City of Albuquerque Stormwater Construction Site Inspection Report

ESC File No.	H14E111	Project Name:	Phoenix Apartments		
NPDES Id. No.	NMR10047E	Location:	2818 4th St. NW		
8/12/2022	Owner			Contractor	
Operator	Michael Dreskin				
Contact name & title	Michael Dreskin				
e-mail	mdreskin@aol.com				
Contact Phone #	249-7788				
COA Inspector	Doug Hughes		Start/End Time:	11-11:30am	
Construction Phase:	Staging				
Type of Inspection:	<input checked="" type="checkbox"/> Regular	<input type="checkbox"/> Storm Event	<input type="checkbox"/> Past Storm Event >0.25"	<input type="checkbox"/> 311/Complaint	<input type="checkbox"/> Follow Up
Weather at time of inspection?	Clear		Temperature:	~ 80	
Estimated date of last storm 0.25" or greater	8/1/2022

TEMPORARY EROSION AND SEDIMENT CONTROL PLAN

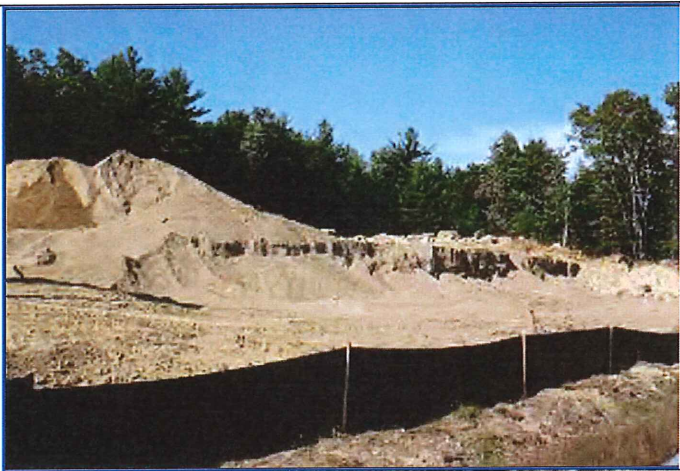
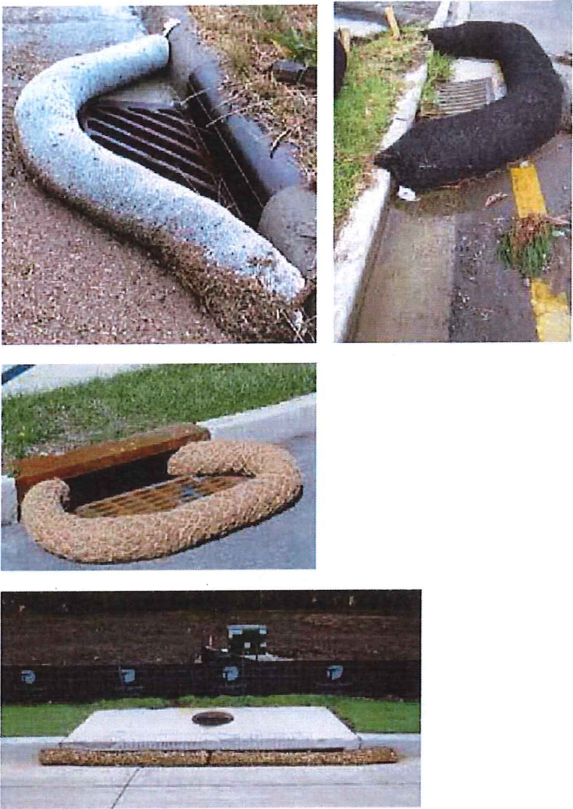
Item Number	Deficiency/ Corrective Action				
1	The SWPPP wasn't available at the time of inspection. The 2017 permit coverage expired and EPA records show it wasn't extended. Self Inspection Reports weren't available. CGP 4 The up-to-date SWPPP must be available onsite CGP 7.1 and new permit coverage must be obtained.				
2	Silt Fence wasn't properly installed. BMPs must be reset within 7 working days CGP 5.2.1				
3	Concrete washout was on the ground. Direct wash water from concrete, paint, and stucco into a leak-proof container per CGP 2.3.4. Remove and dispose of hardened concrete with other waste per CGP 2.2.3.				
4
